384 Frank Street | *Formal Review* | Zoning Amendment and Site Plan | unpoised Architecture; Novatech Planning & Engineering

west elevation

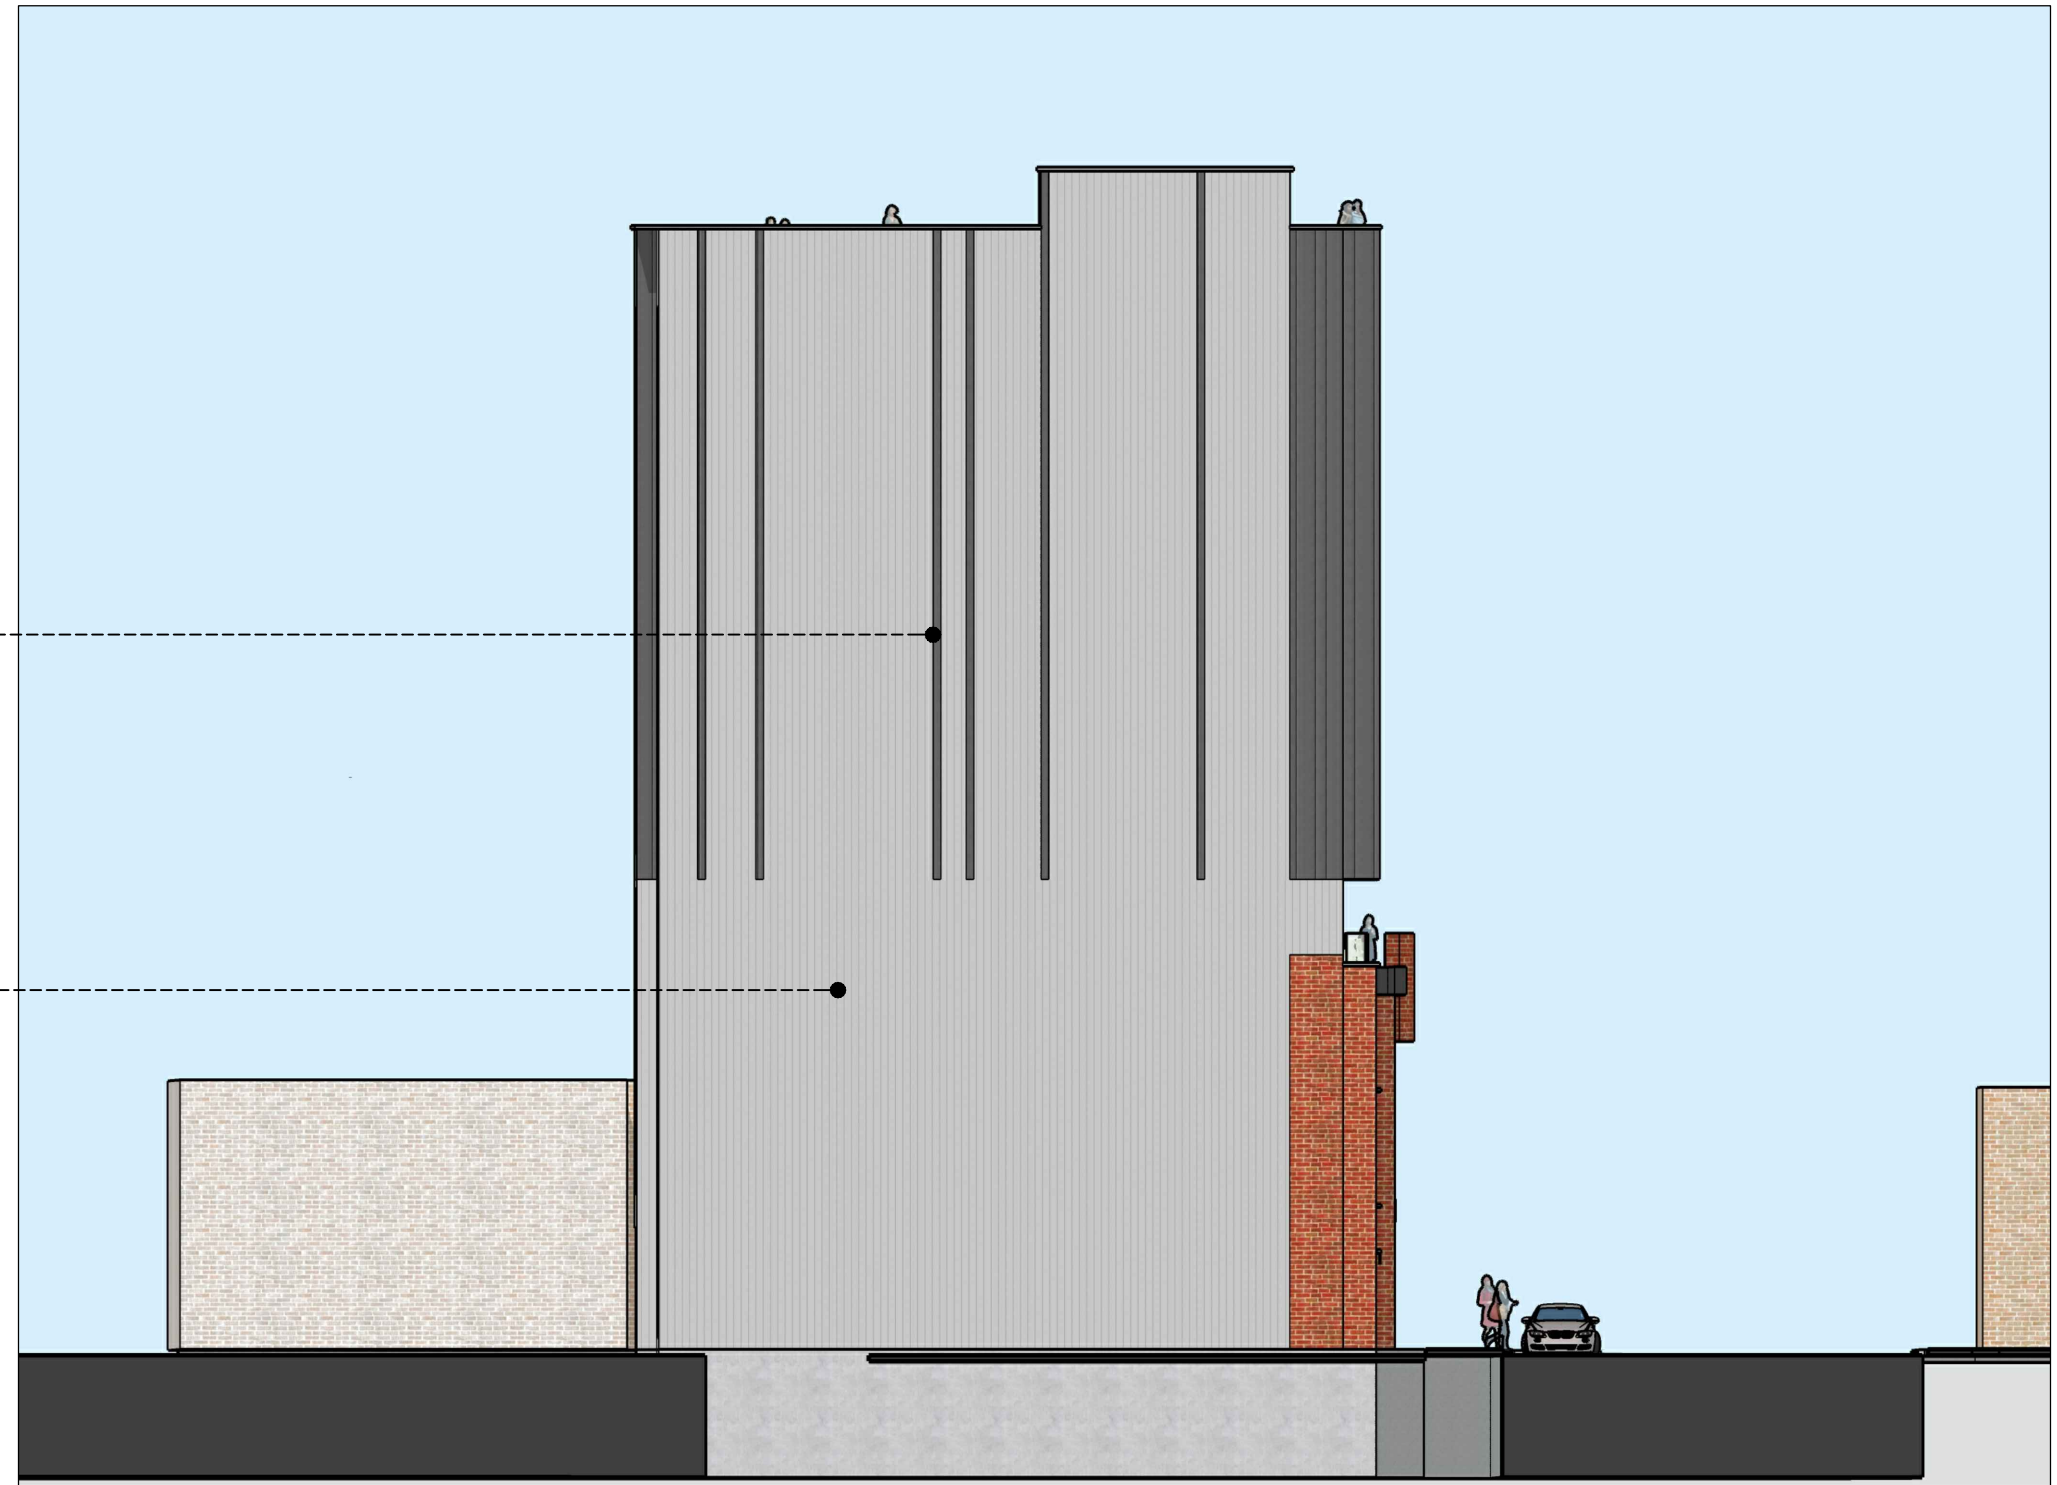
- The Panel appreciates the animation of the wall facing Bank Street, given the inability to add fenestration to this wall, however is concerned that the five stories of exposed wall visible from Bank Street does not represent a successful transition, and will appear like a dark cloud over the street. Since the proposed building is not connected directly to Bank Street, the Panel finds that the property should be developed as a transitional site between the medium density residential area to the east, and the traditional main street condition on Bank Street.

- The Panel appreciates the cleaner and clearer volumes of the revised plans, and believes that the building is now better grounded. The use of colour, and the architectural explorations evident in the massing, the expression of the base, and the notch at the top, are successful.
- The Panel does have concerns that the dark treatment proposed for the wall facing Bank Street is not appropriate given its volume.
- There is some concerns from a Panel member that the appliqué brick element on the base needs some refinement, with particular consideration for its visibility from Bank Street.
